KITTITAS COUNTY

DEPARTMENT OF PUBLIC WORKS

MEMORANDUM

TO: All Staff
FROM: Public Works Plan Review Team
DATE: January 24, 2024
SUBJECT: BL-24-00001 Sligmann

LEGEND

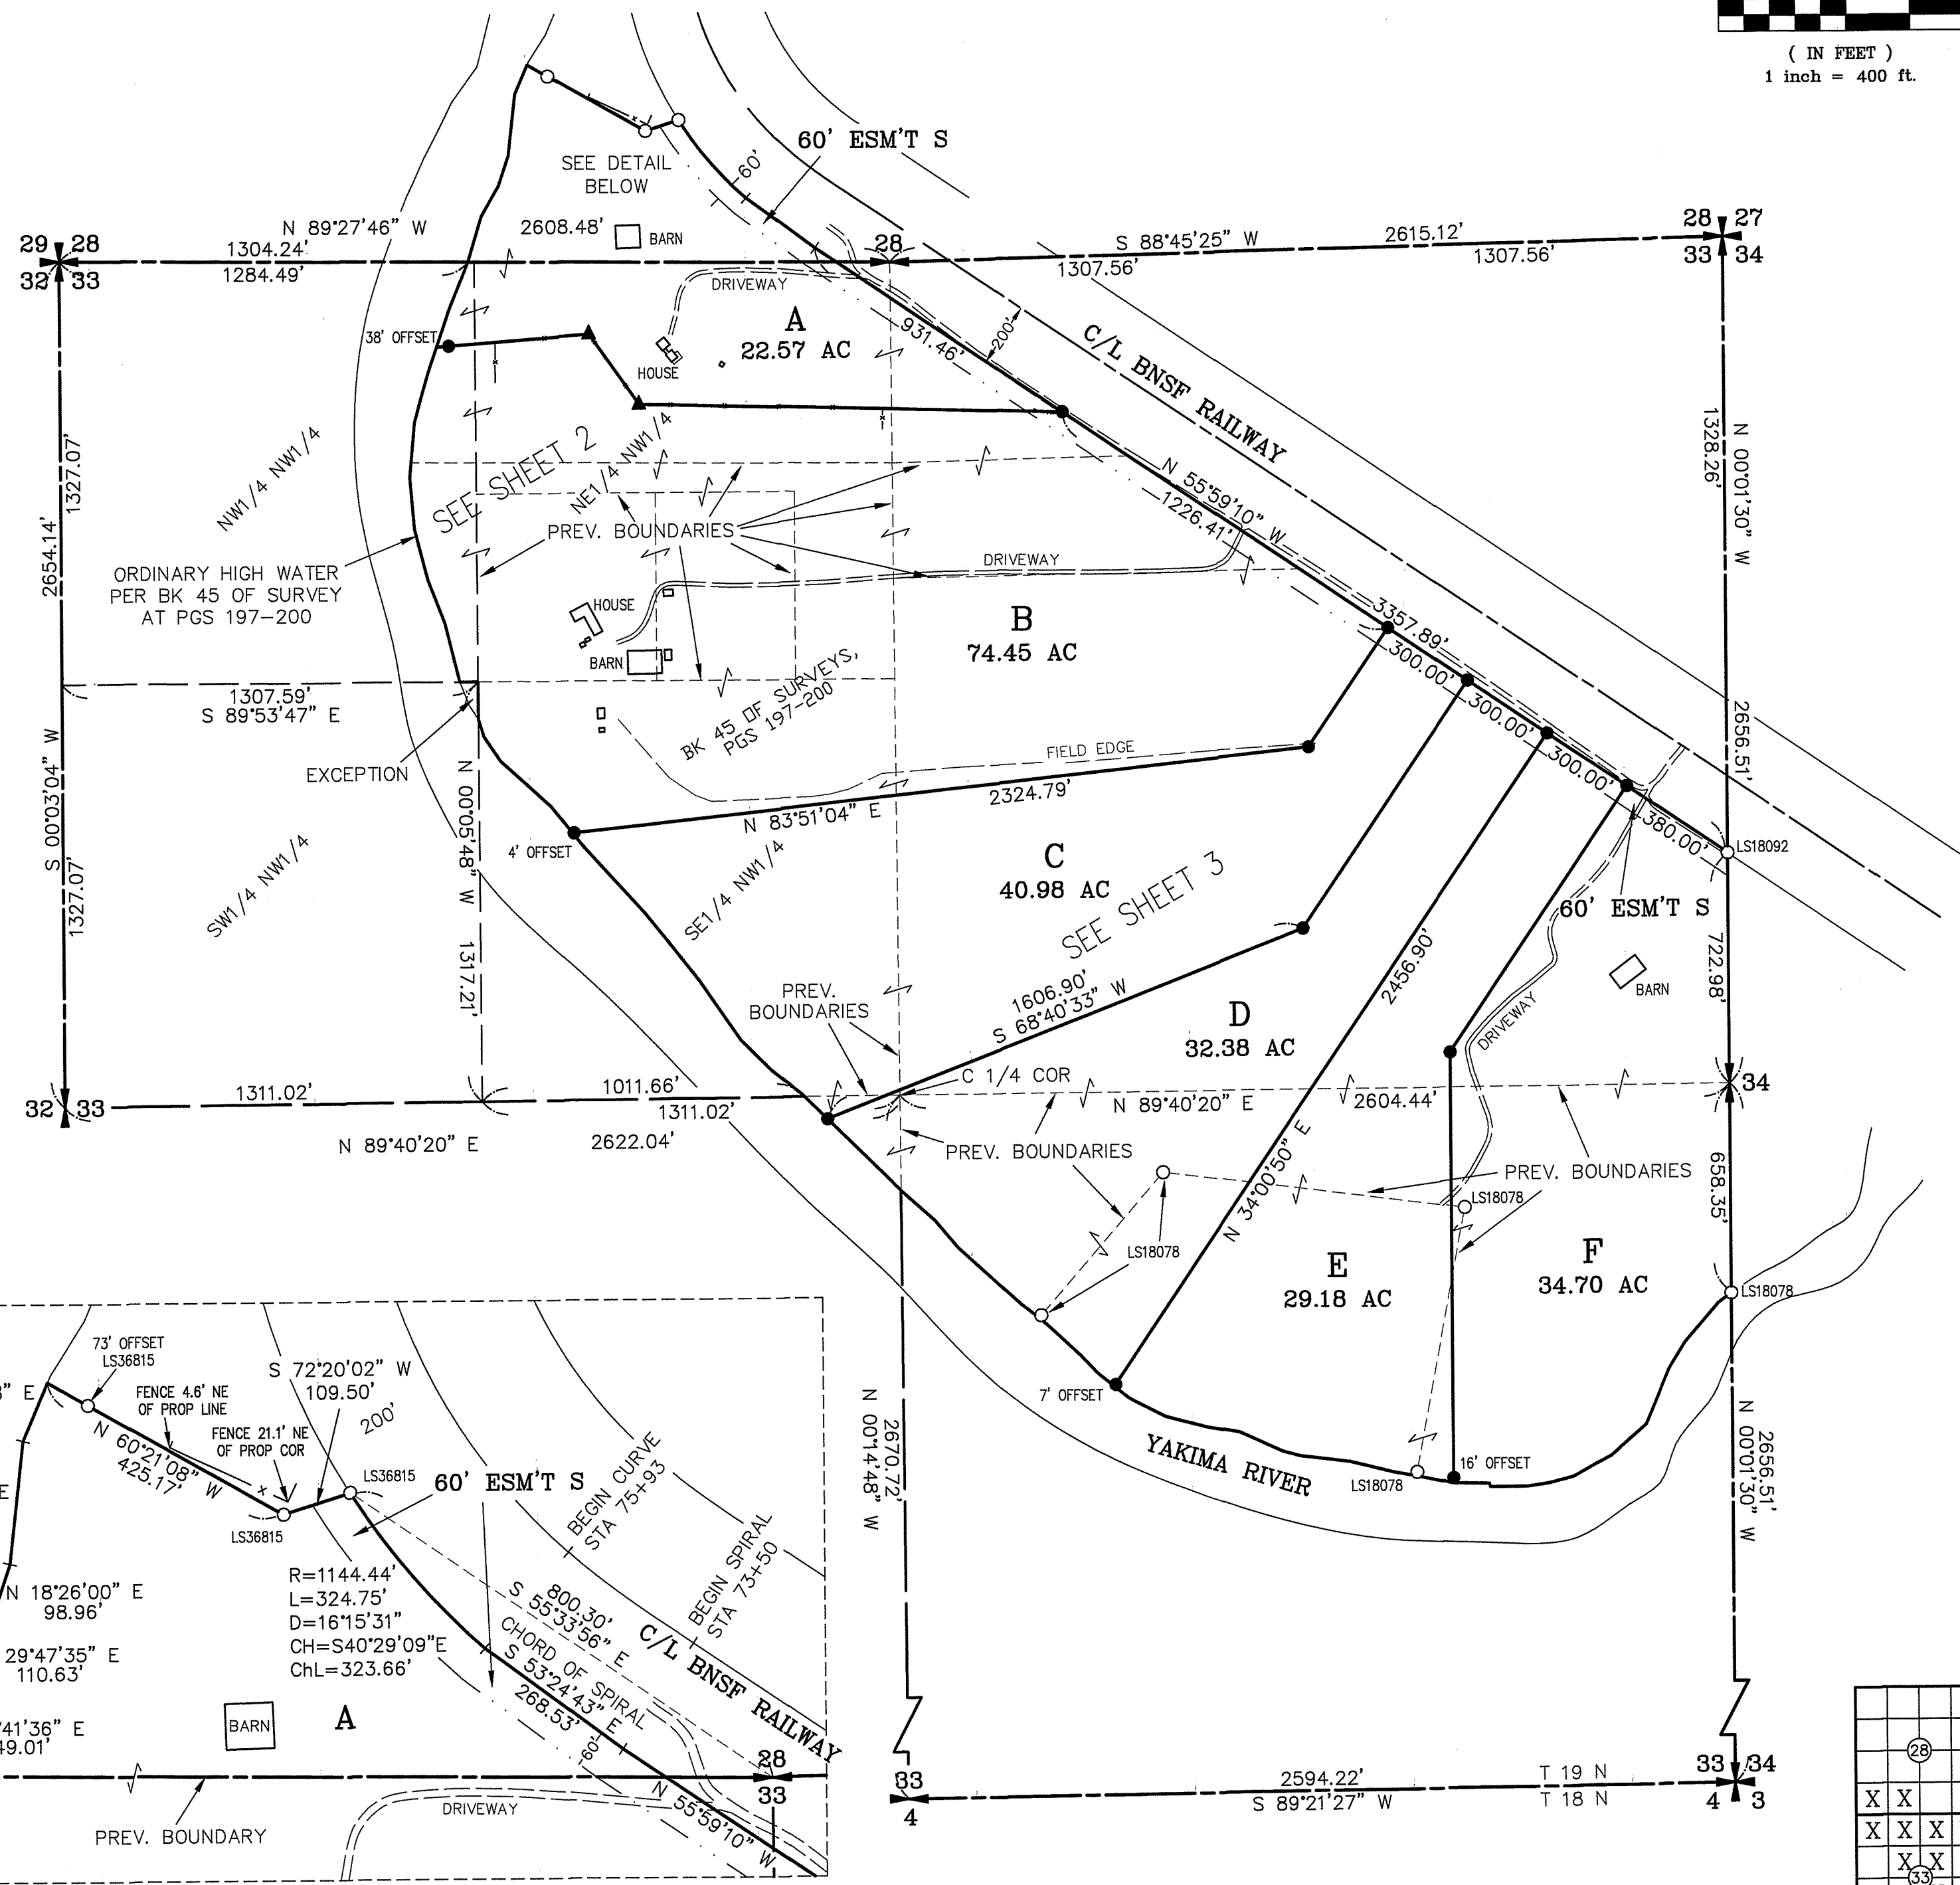
<p>ENGINEERING</p>	<p>Except as exempted in Section KCC 14.05.060, no grading or filling upon a site involving more than one hundred (100) cubic yards shall be performed without a grading permit from the County Engineer or Public Works designee (KCC 14.05.050). An application for grading in excess of five hundred (500) cubic yards shall be accompanied by an engineered grading plan (KCC 14.05.080). (CC)</p>
<p>SURVEY</p>	<p>As the application does not contain a survey map, comments herein reserved until final. (JT)</p> <p>UPDATE (02/16/2024)</p> <ol style="list-style-type: none"> 1. Minor typo in Legend (PK vs PKK)

<p>2. Show legal access to Dudley Road. This is for visual reference only and does not need to be dimensioned. Please include AFN's for any easements or crossing agreements.</p> <p>3. Please include some reference on the face of sheet 1 that Easement S is proposed or to be created via separate document.</p> <p>4. On sheet 3, the Westernmost boundary line bearing of Parcel F is obscured by crossing linework.</p> <p>5. The section corners shown as "Calc" cannot be recreated from the provided references, as no portion of the referenced documents tie to the found corners as shown. Please include suitable notes or document reference so that the methods to calculate these corners can be recreated by others. (While the angle and distance along the north line of the section to calculate the NW corner appear to be from Survey: 17-167, it is uncertain what was utilized to calculate the SE corner position.)</p> <p>OF NOTE (changes not required) Proposal appears to include parcel APN:077834 per county GIS. County Assessor is working on resolving this.</p> <p>UPDATE (03/04/2023) 1. Please include some reference on the face of sheet 1 that Easement S is proposed or to be created via separate document.</p>
